**re: Geotechnical Response to City Comments**  
**Proposed Mix-Use Development**  
**1131-1151 Teron Road - Ottawa**

**date:** September 20, 2021

**file:** PG5283-MEMO.02

DRAWING NO.
C02

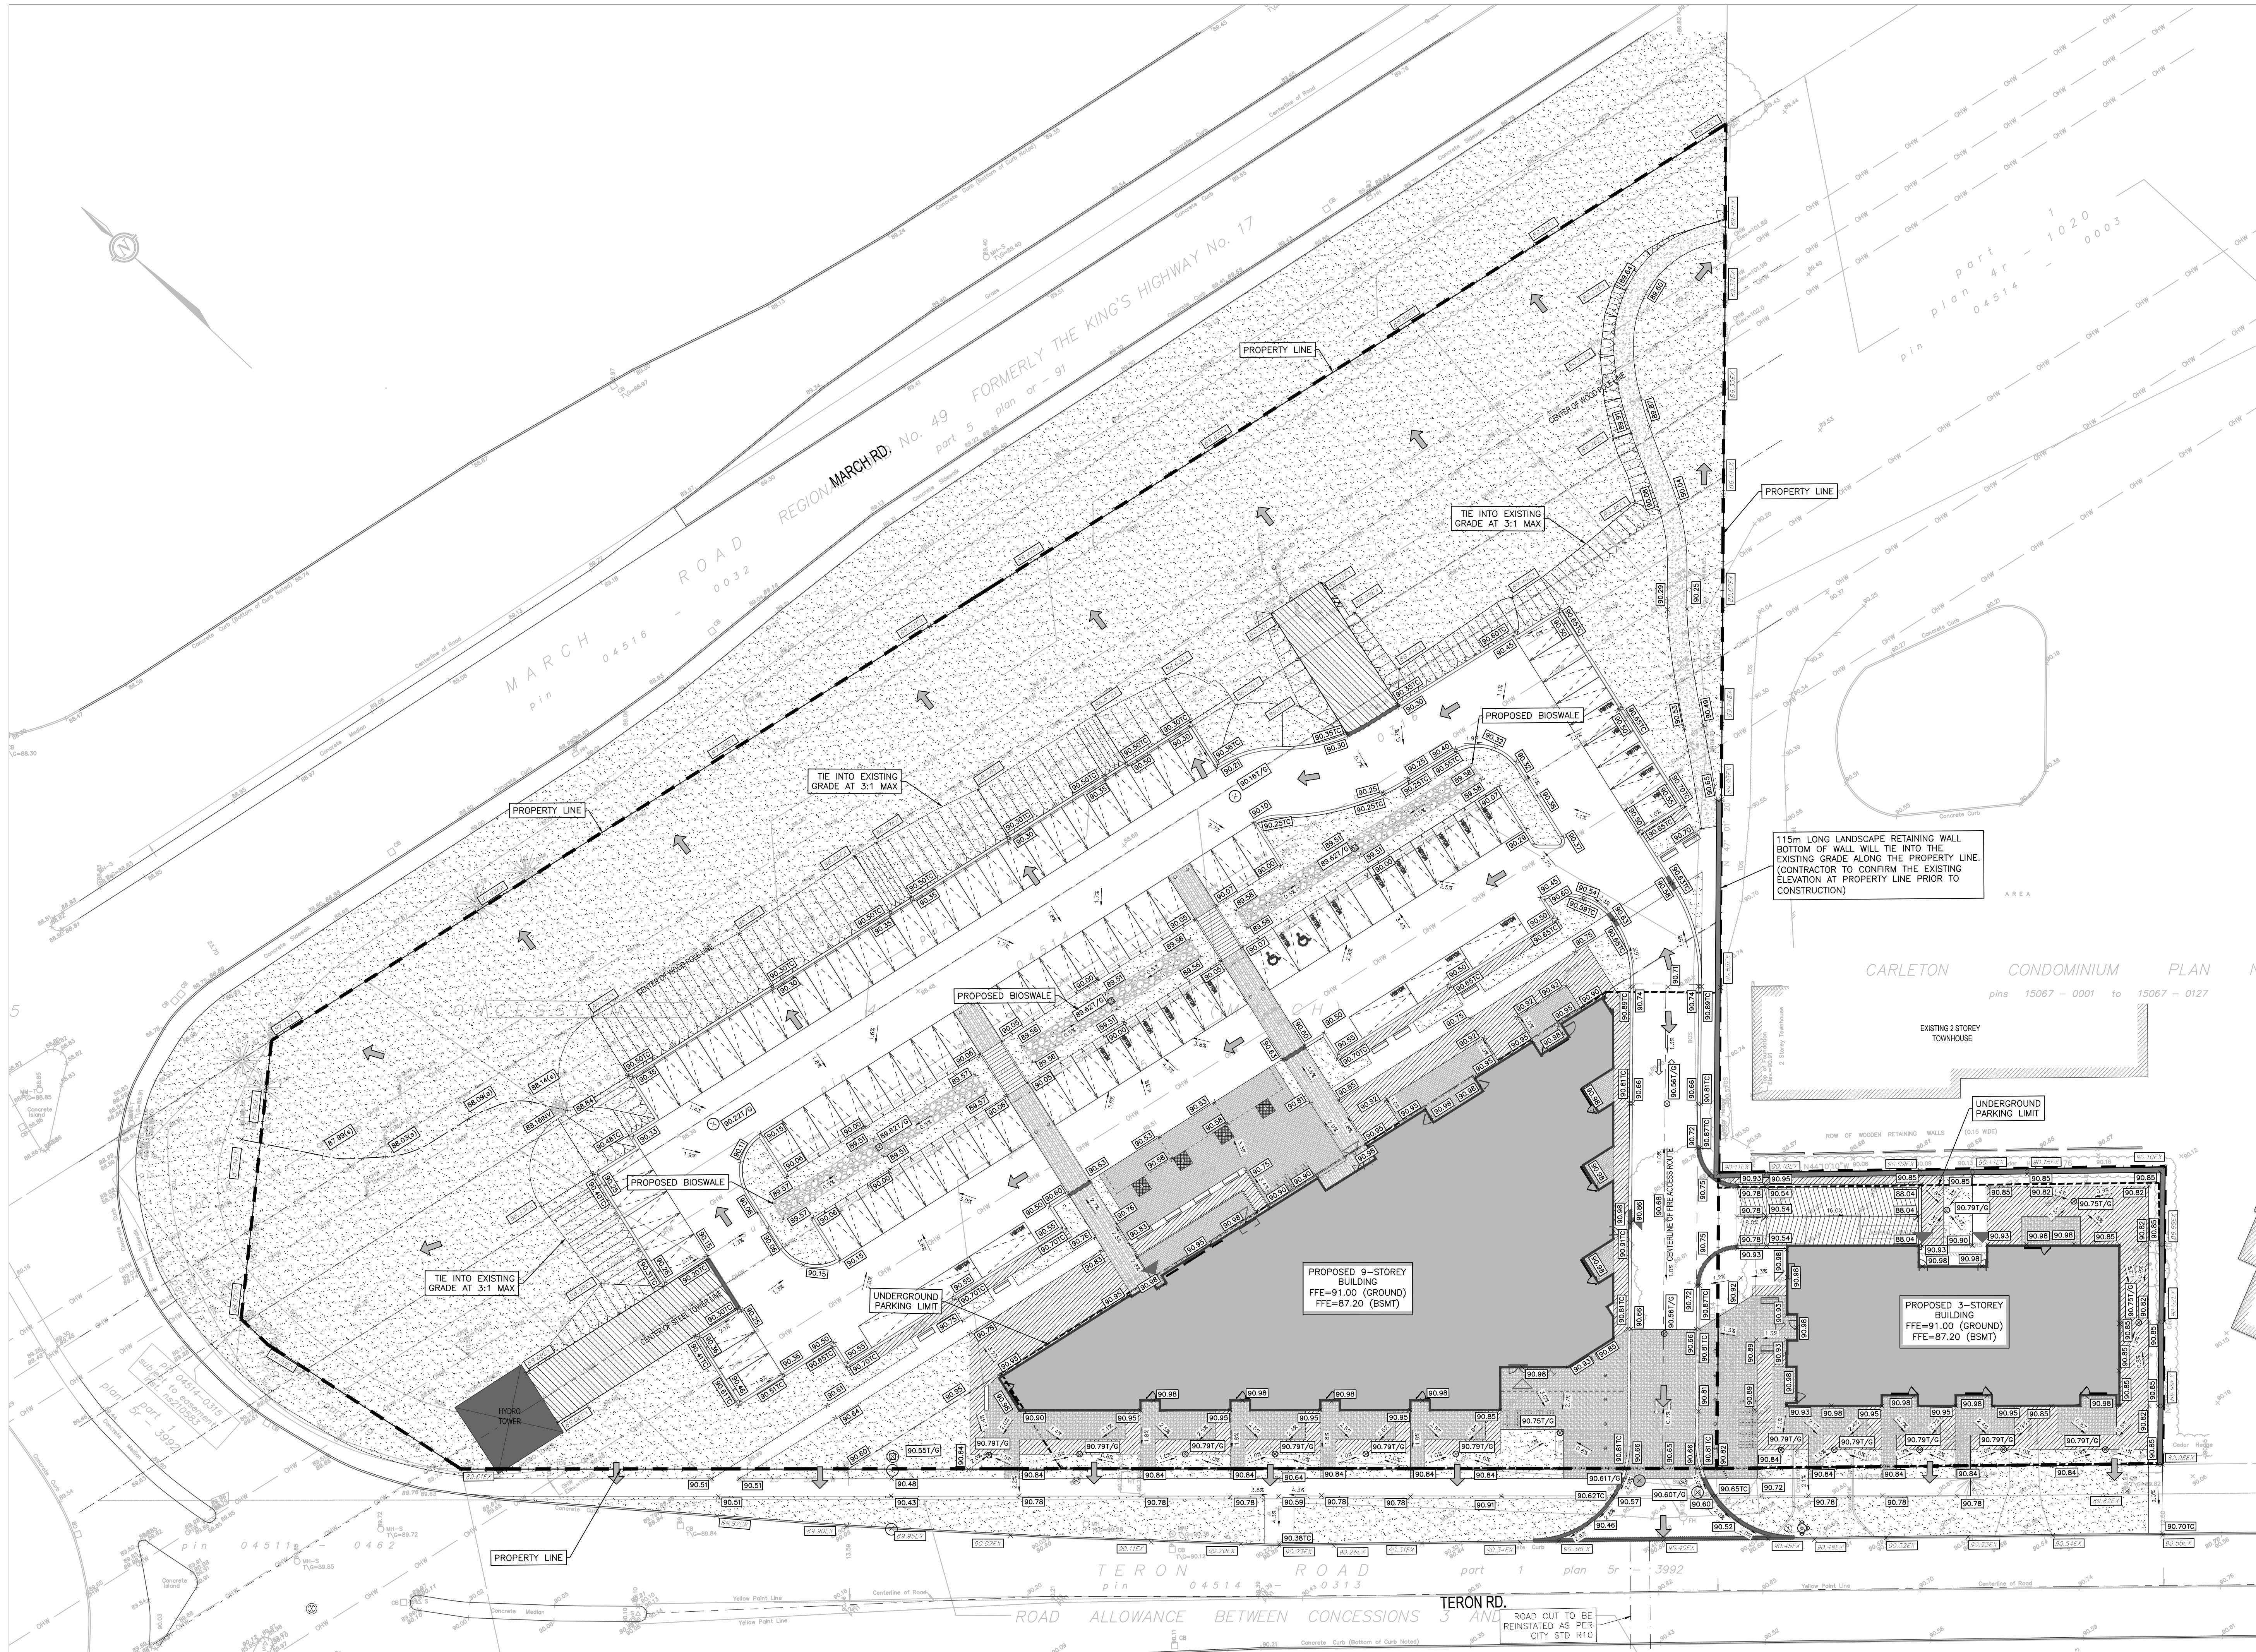
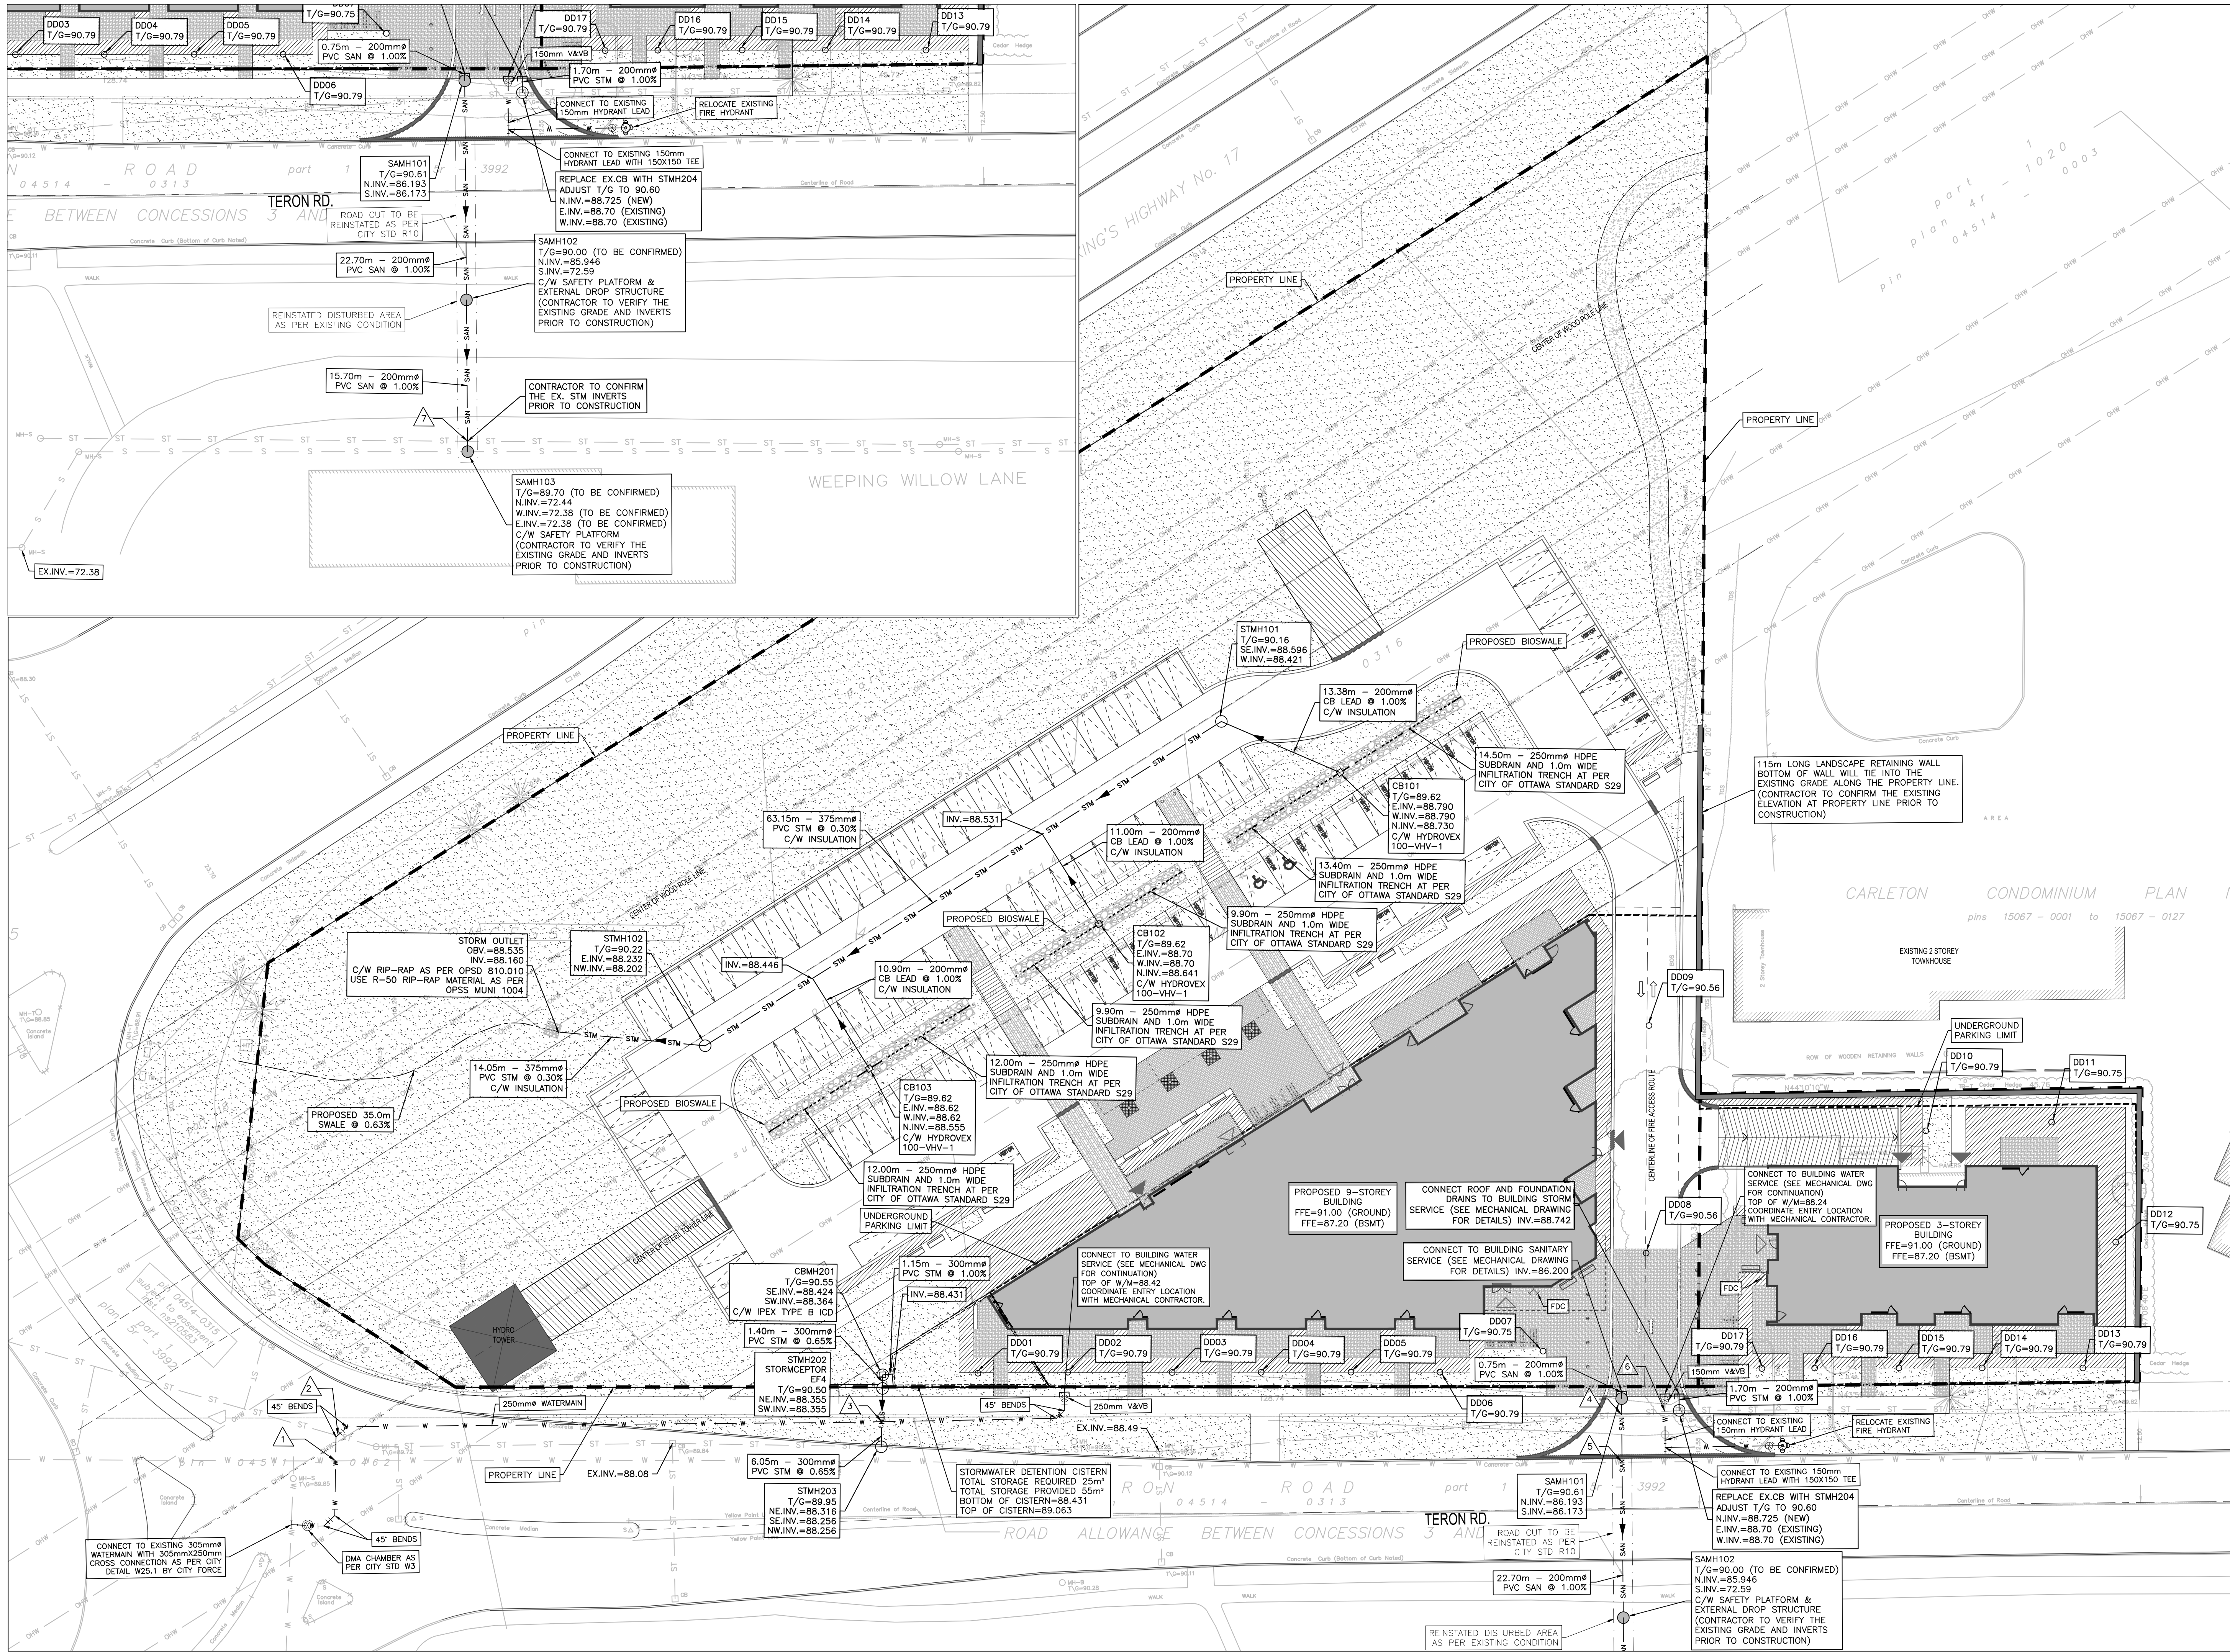
Project No. 20M-01534-00 – Grading Plan – Drawing No. C02 Revision 2, dated September 3, 2021.

Based on our review of the above noted drawing, the proposed grading coincides with the permissible grade raise restrictions with no exceedances noted. Therefore, the proposed grading is considered acceptable from a geotechnical perspective and no lightweight fill will be required for the proposed building.
